City of Albuquerque Stormwater Construction Site Inspection Report

ESC File No.	H13E109A	Project Name:	Sandia Lab FCU		
NPDES Id. No.	NMR1004MR & '4U0	Location:	1100 Rio Grande Blvd NW		
5/8/2023	Owner	Contractor			
Operator	Garcia Real Estate Investments, LLC		Insight Construction		
Contact name & title	Ed Garcia		Dave Brown		
e-mail	eeegarcia@garciacars.com		Dave@insightnm.com		
Contact Phone #	505-259-0339		505-506-8412		
COA Inspector	Doug Hughes		Start/End Time:	10am	
Construction Phase:	WO complete and BP vertical				
Type of Inspection:	<input type="checkbox"/> Regular	<input type="checkbox"/> Storm Event	<input type="checkbox"/> Past Storm Event >0.25"	<input type="checkbox"/> 311/Complaint	<input checked="" type="checkbox"/> Follow Up
Weather at time of inspection?		clear		Temperature:	~ 70
Estimated date of last storm 0.25" or greater		3/16/2023

RONALD R. BOHANNAN P.E. #7868	<b>SANDIA LAB FCU</b> <b>RIO GRANDE AND I-40</b> <b>SWPP PLAN</b>	DRAWN BY LN
		DATE 06/23/21
		2012100-SWPPP
		SHEET # <b>C6.1</b>
 <b>TIERRA WEST, LLC</b> 5571 MIDWAY PARK PLACE NE ALBUQUERQUE, NM 87109 (505) 858-3100 www.tierrawestllc.com		JOB # 2012100

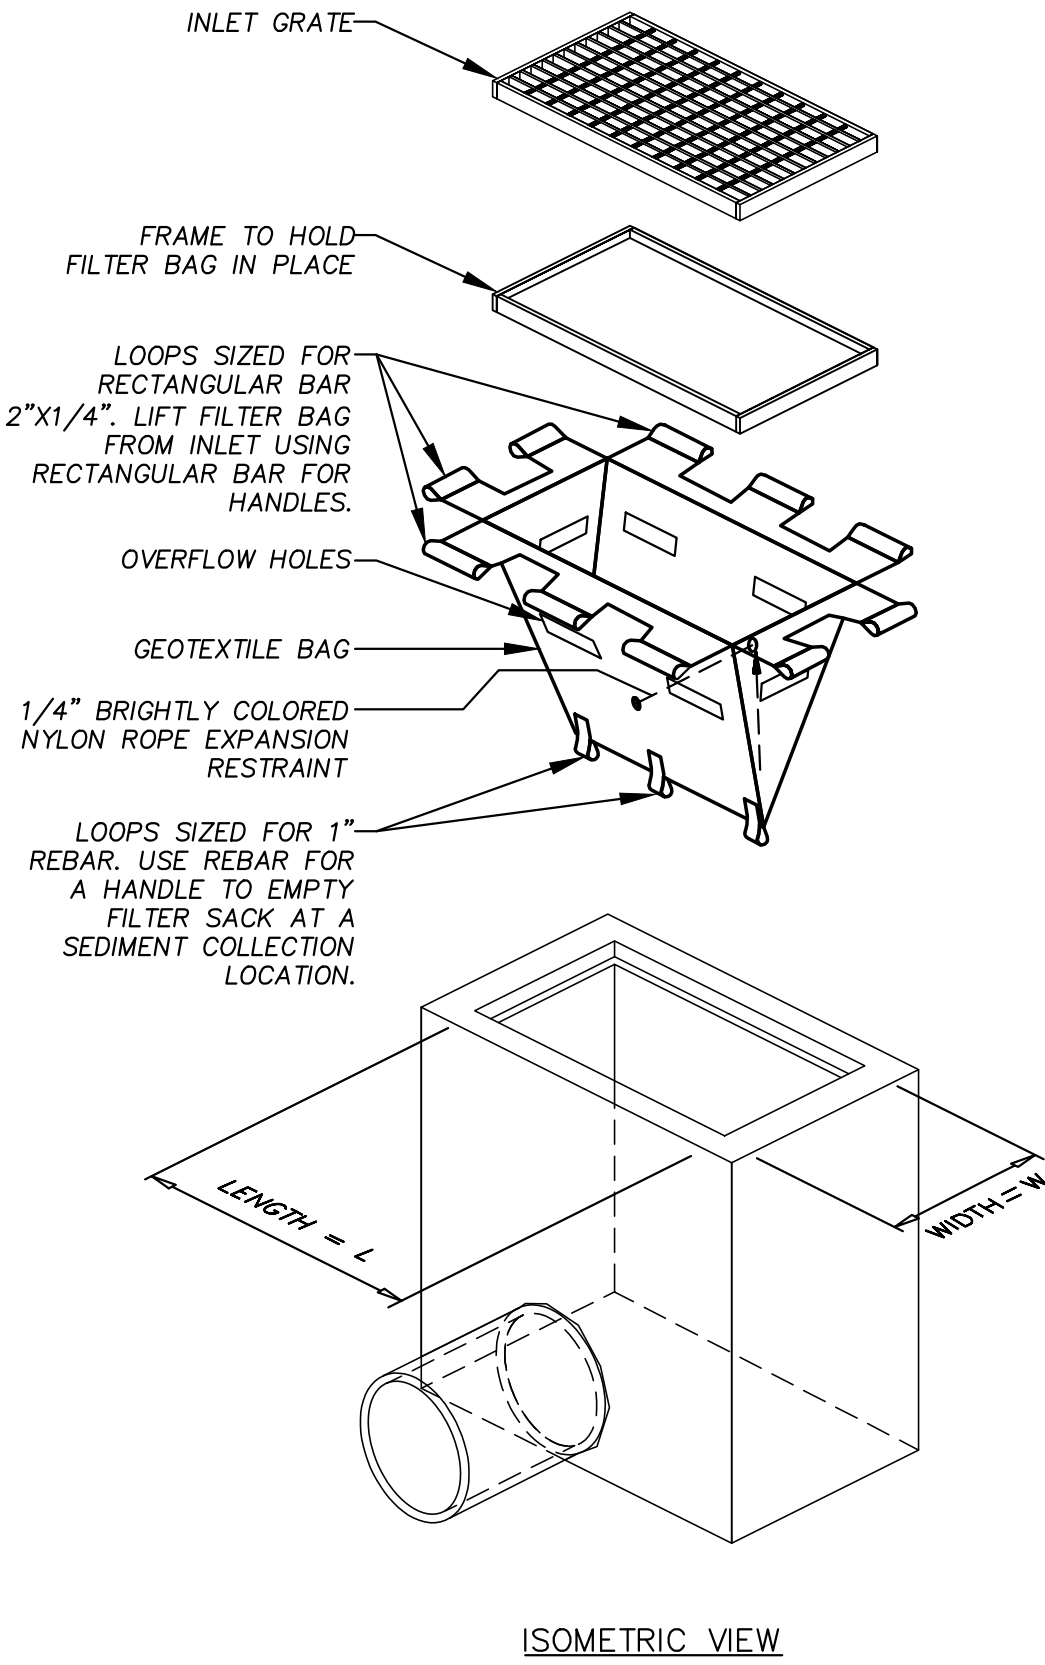
Notes: The SWPPP is in the conex on site. It contains the property owner's NOI, the CGP, and some old self-inspection reports (most recent is 8/24/22). The SWPPP map needs updated. The Property

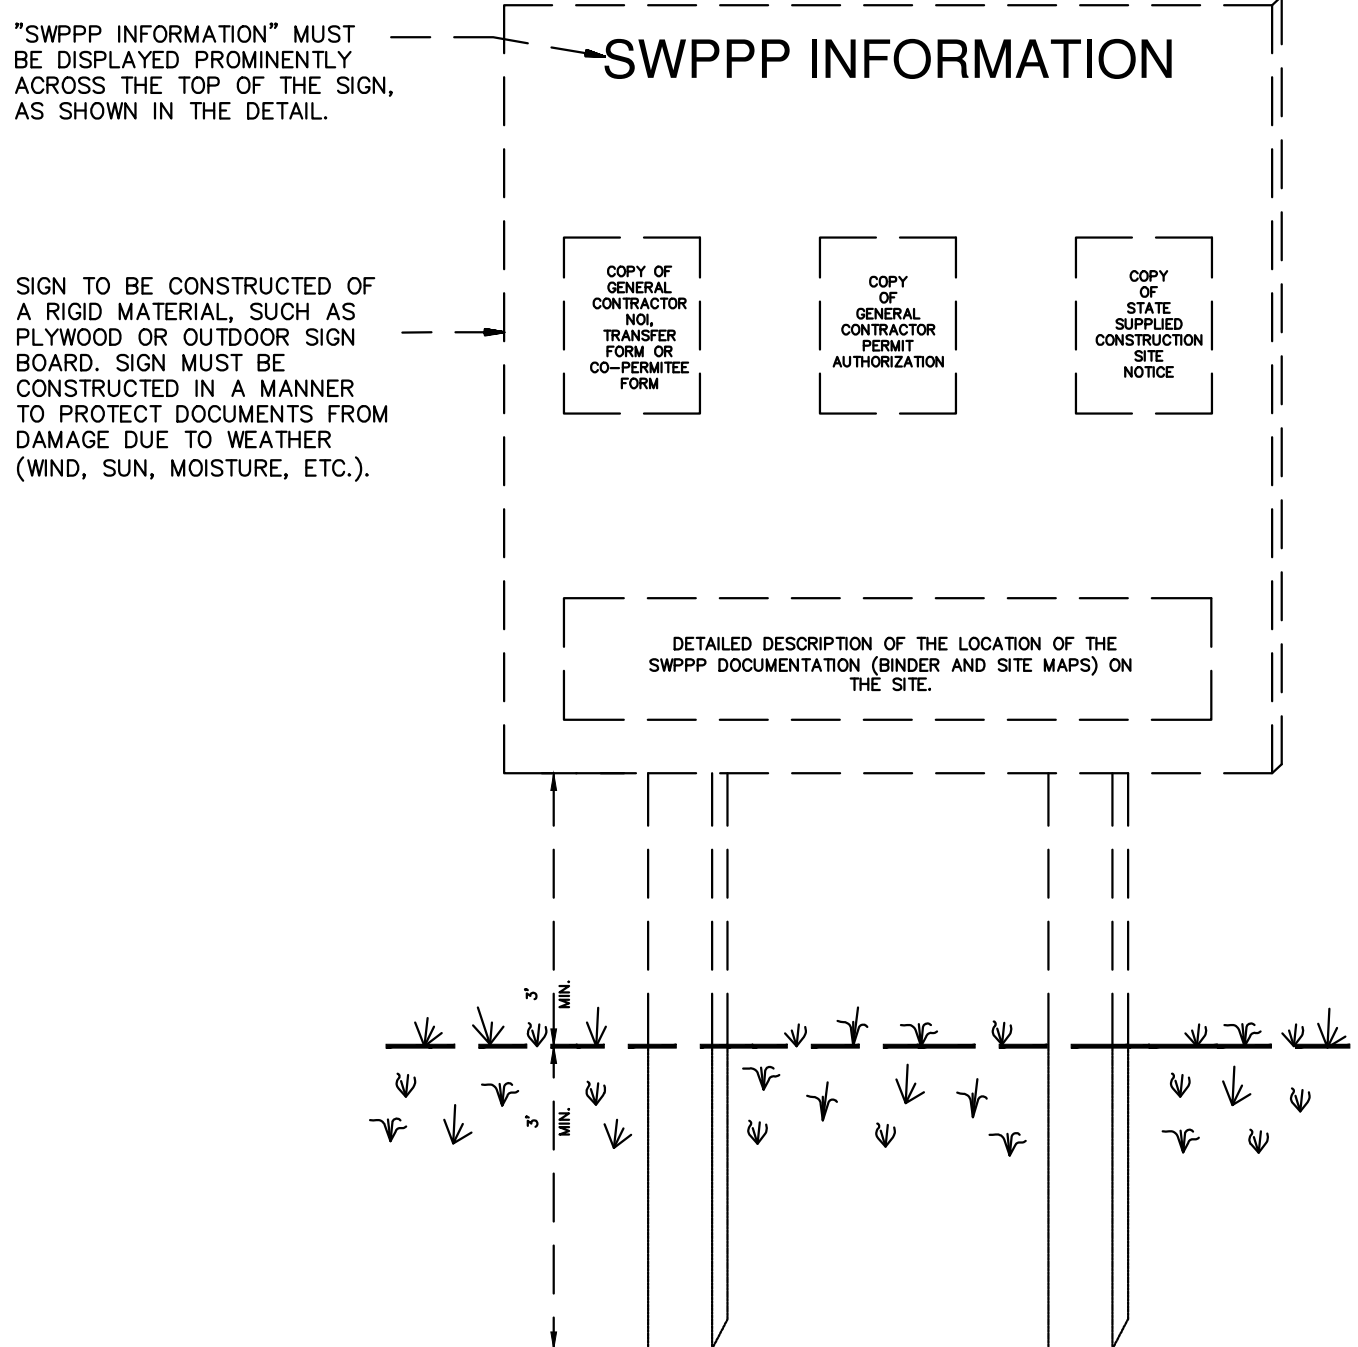
Item Number	Deficiency/ Corrective Action				
1	Posting - Incomplete and wrong place. The NPDES ID # and point of contact are missing and must be included on the sign. You must post a sign or other notice of your permit coverage at a safe, publicly accessible location in close proximity to the construction site. The notice must be located so it is visible from the public road that is nearest to the active part of the construction site, and it must use a font large enough to be readily viewed from a public right-of- way per CGP 1.5.				
2	Conduct self-inspections Once every 14 calendar days and within 24 hours of the occurrence of a storm event of 0.25 inches or greater per CGP 4.2 and City ESC Ordinance § 14-5-2-11(C)(1) until final acceptance of site stabilization by the city. Keep signed copies of Self-inspection reports per CGP 4.7 and Corrective Action reports per CGP 5.4 with the SWPPP on-site, and provide a copy via e-mail to me.
